RE: **Lot 18 Block 5 Unit 18 Volcano Cliffs SAD 228**
6624 Sujeto NW
Grading and Drainage Plan
Engineers Stamp Date 7/20/17 (D10D003K18)

Based upon the information provided in your submittal received 7/21/17, this plan is approved for Grading Permit.

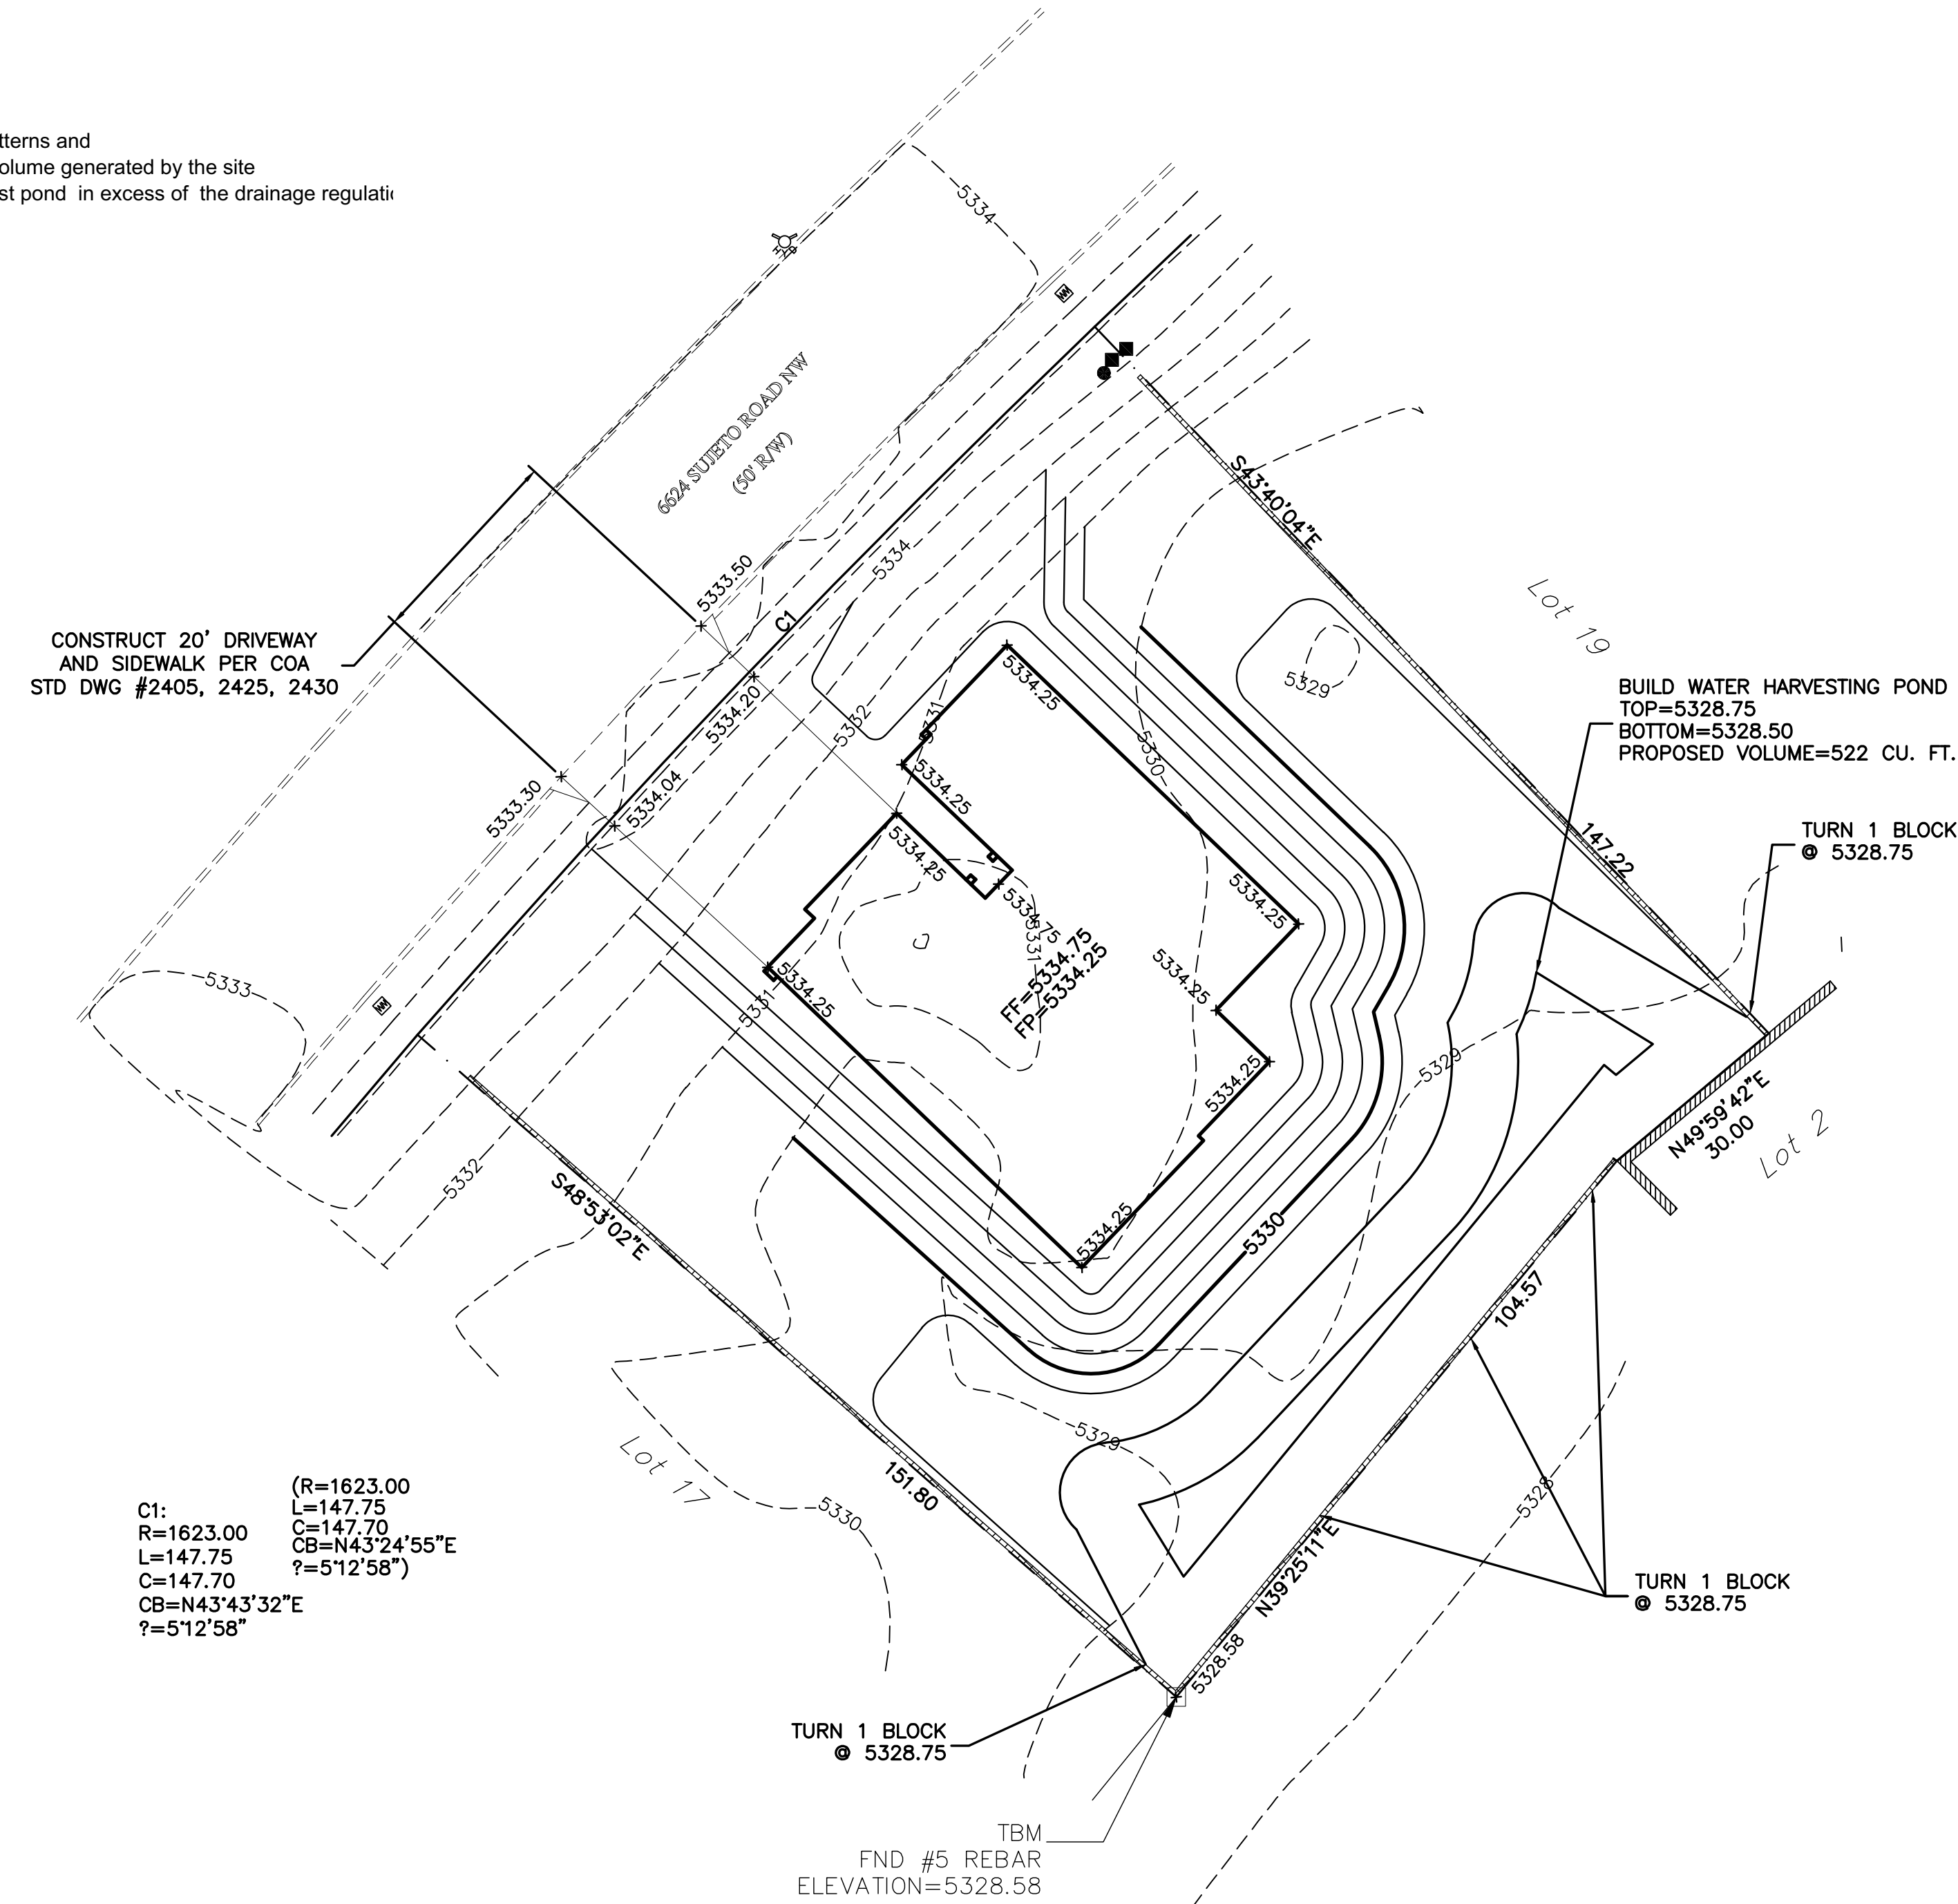
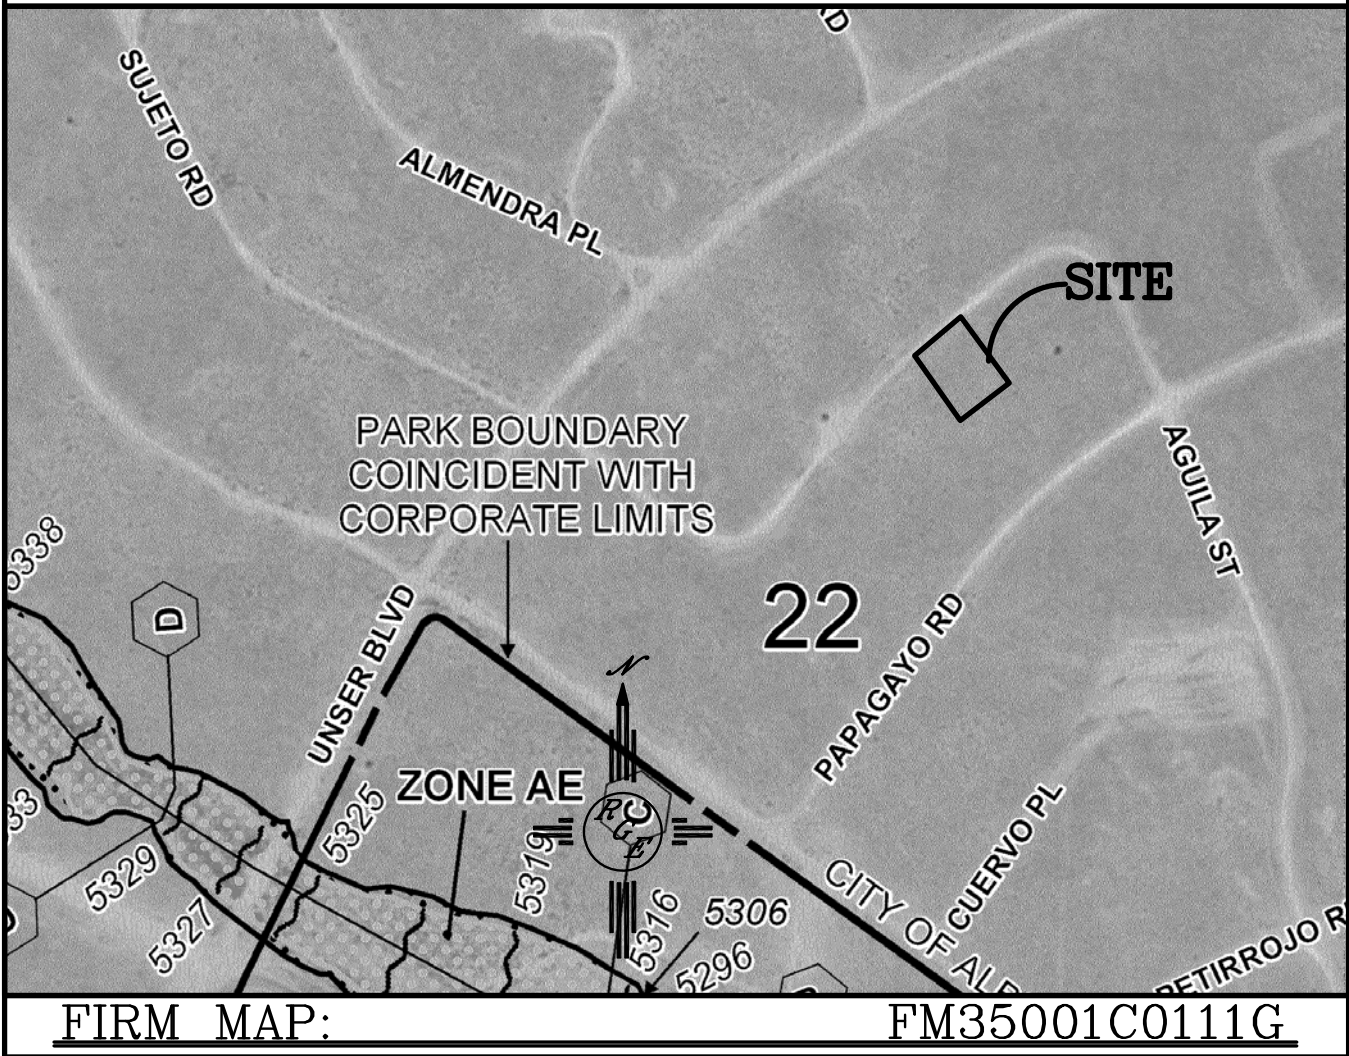
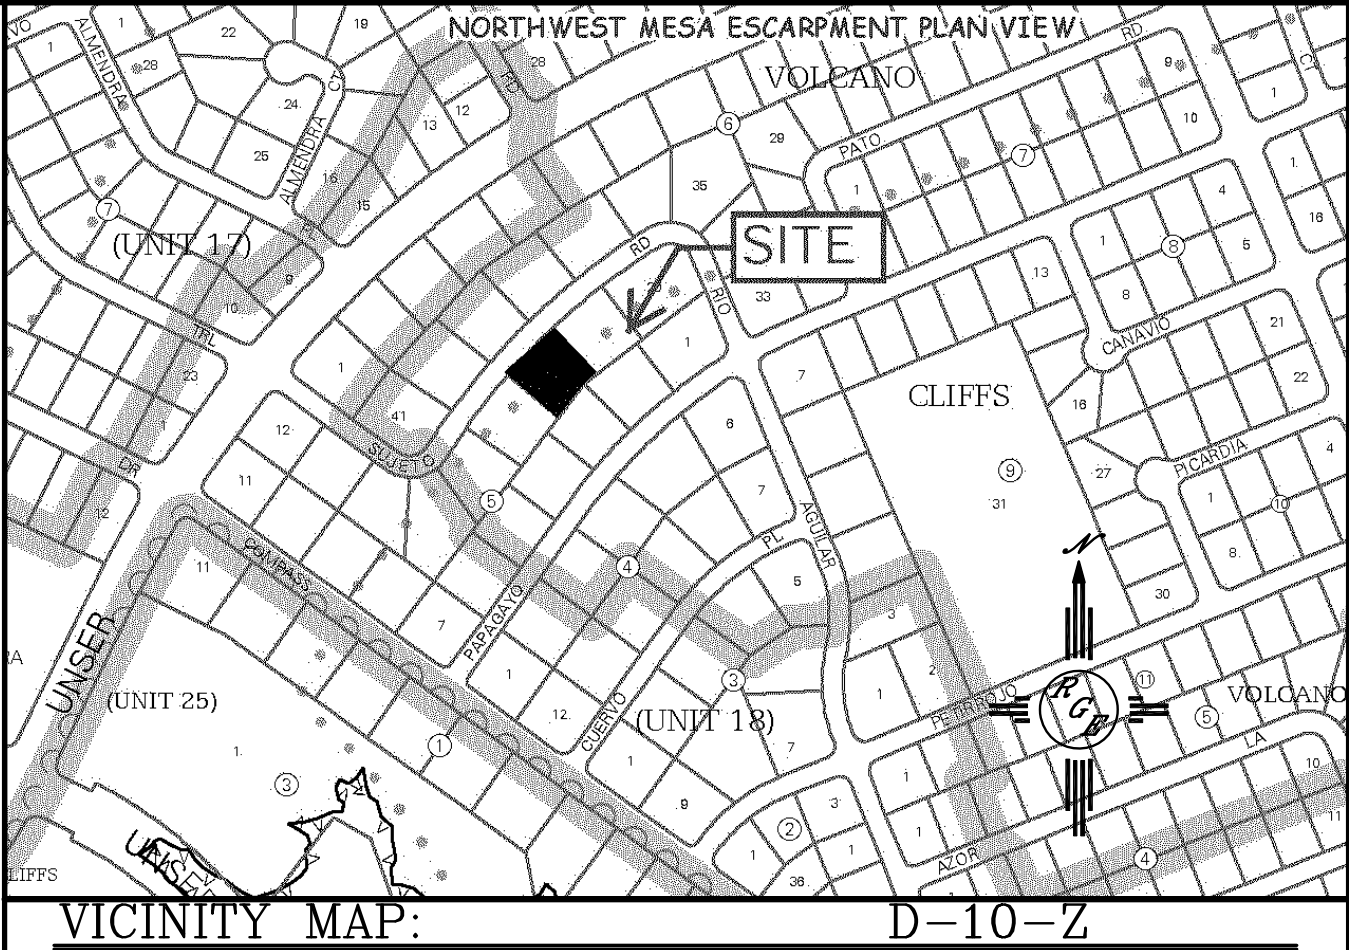
- Provide calculations for the openings in the walls. **we have added the calculations**
- Show the 7 foot P.U.E. **We have shown the PUE**

Each opening is 6"x6"
Each block has two openings
Each opening has .52 cfs capacity
Each turned block has a 1.04 cfs capacity
